Harnett County Government Complex  
307 W. Cornelius Harnett Boulevard  
Lillington, NC 27546

**Re: Existing Tank Application: # BRES2207-0011**

New deck Plan
97 Setter court
Angier NC

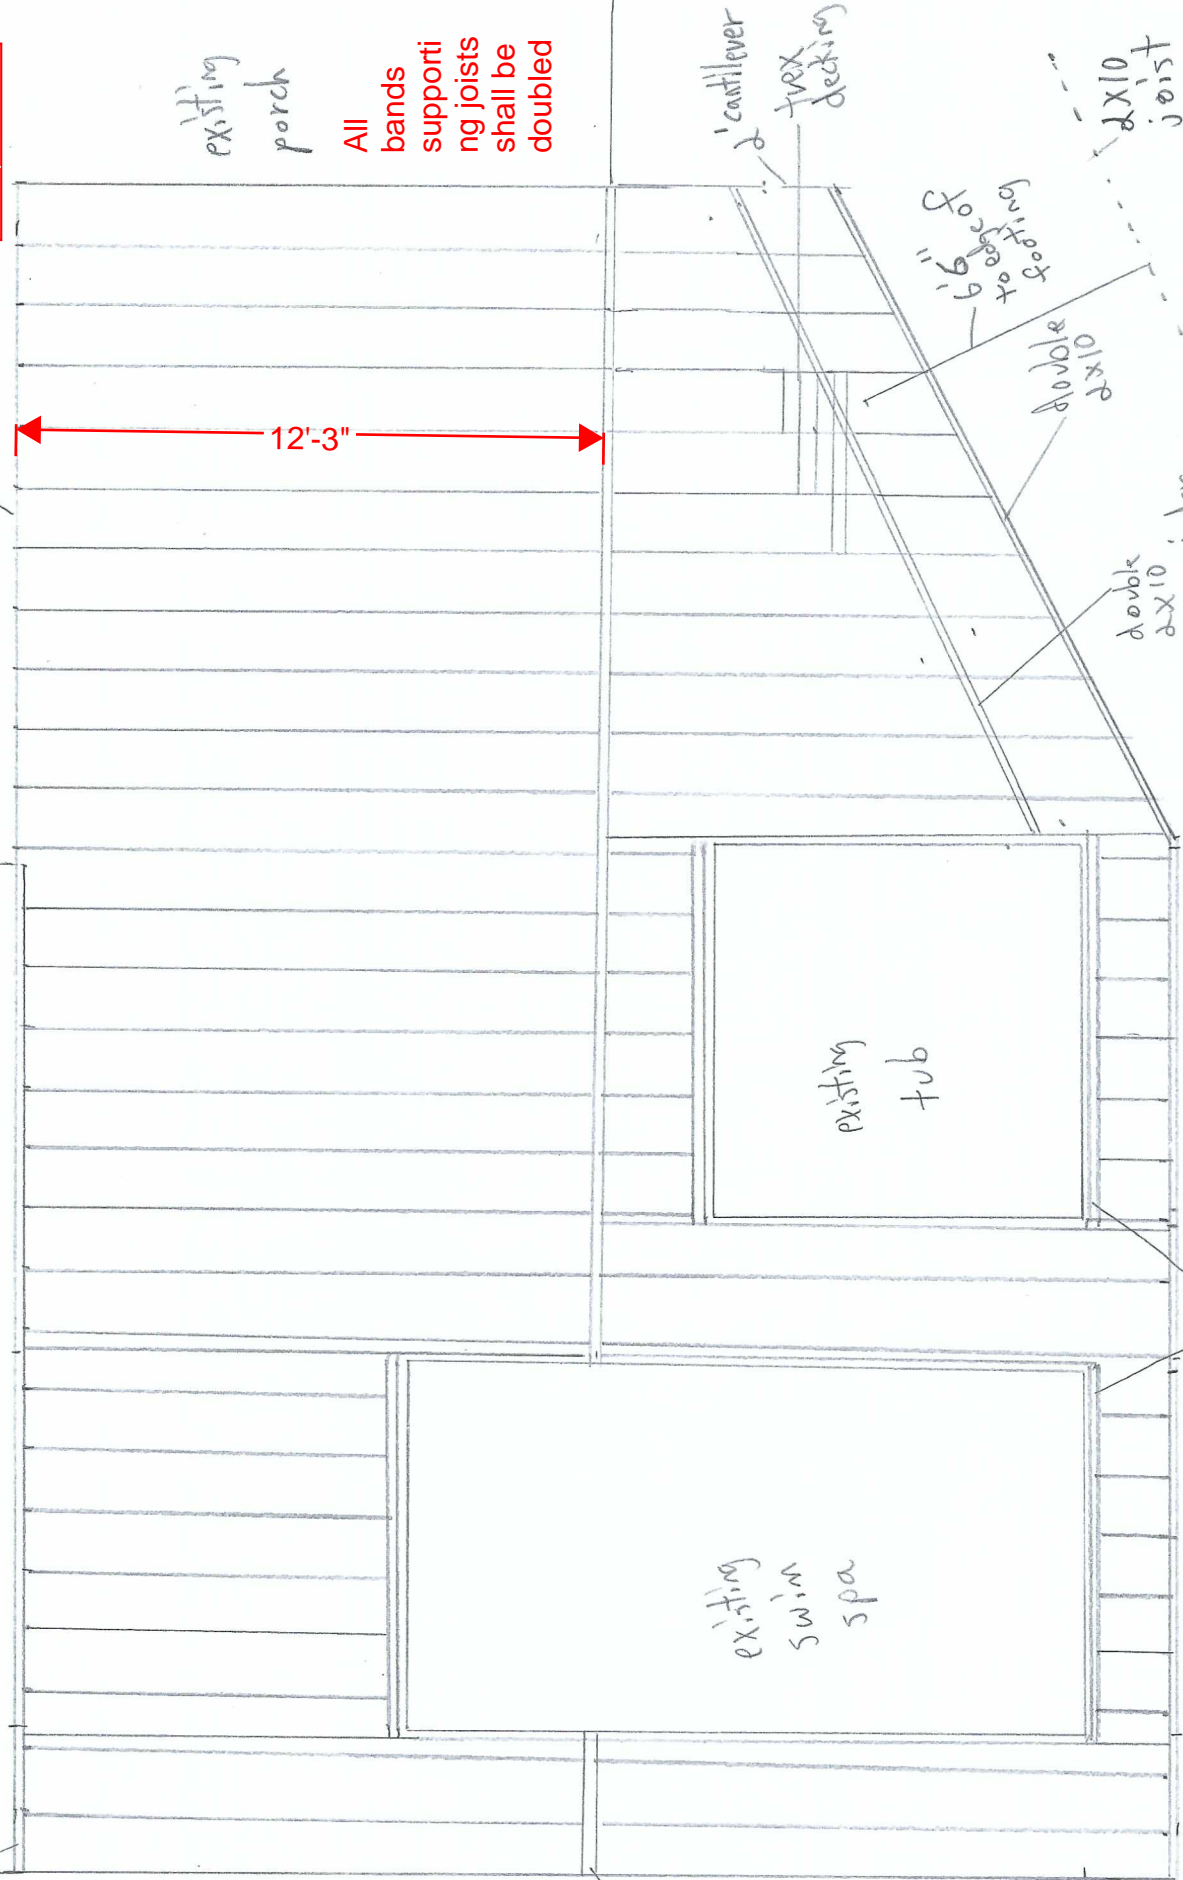
**X 4. Other – Disapproval – Septic Encroachment – Proposed deck encroaches upon existing septic field (see Operational Permit). Closest line to proposed deck marked onsite and located via ground radar. Proposed deck shall be revised to meet 5ft minimum septic setbacks (6.5ft from flags since marked at center). Revise site plan with any foundation pillar greater than 6.5ft minimum from field and mark structure out accordingly onsite. Reconfirm when ready for revised approval.**
